Application No: P/132/20/RES
Site Address: Land north of Hook Lane Pagham
Description of works: Approval of reserved matters following P/30/19/OUT for 300 No. new homes, internal roads, footpaths & cycleways, car parking & landscaping. This application affects the setting of a listed building & falls within Strategic Site H SP2, CIL Zone 1 (Zero Rated).

Thank you for your internet representation made on 31st January 2021 which has been recorded as an objection with the comments as follows:

This is the response on behalf of Sustrans and the Bognor Regis Cycle Forum.

Project	Hook Lane, Pagham		
Drawing	Bin and Bicycle Store 1 Plan and Elevations		
Client	Hallam Land		
Job no.	HALL200505	Date	Dec' 2020
Dwg no.	BCS.01.pe	Rev.	A
Author	MWP	Checker	Scale 1:100 at A3
Status	PLANNING	Office	Romsey
Client ref.

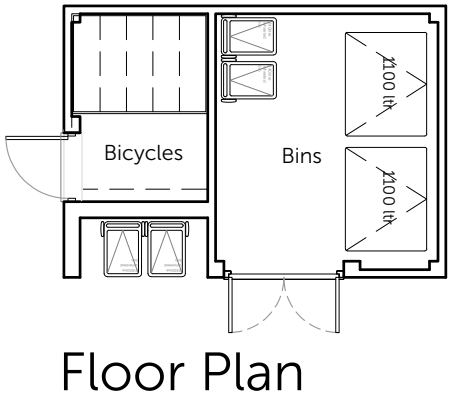
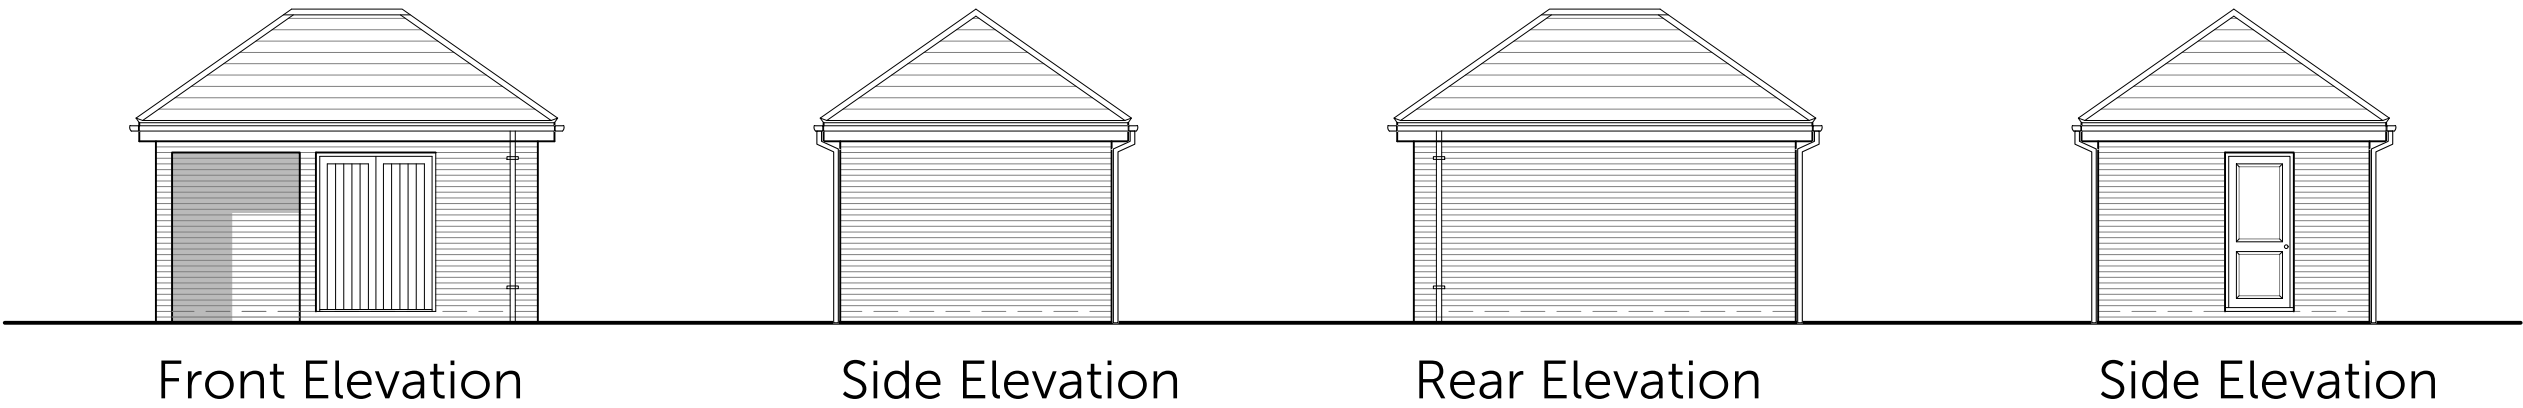
In respect of the proposed Bin & Bicycle Stores and the Car Barn with Cycle parking/Bin Storage, it's not clear if the cycle parking is simply intended to be an area to leave bikes, nor what sort of security is intended to be in place. It's estimated that around 500,000 bikes are stolen each year in the UK, with over half of all bike thefts being from residential properties. If people do have a bike stolen, then around 30% don't replace it and stop cycling completely whilst a further 20% don't cycle so much in the future. Therefore, it's vital that high quality and secure cycle parking is provided in order to reduce bike theft and ensure people keep cycling. The cycle parking areas must include concreted in Sheffield stands.
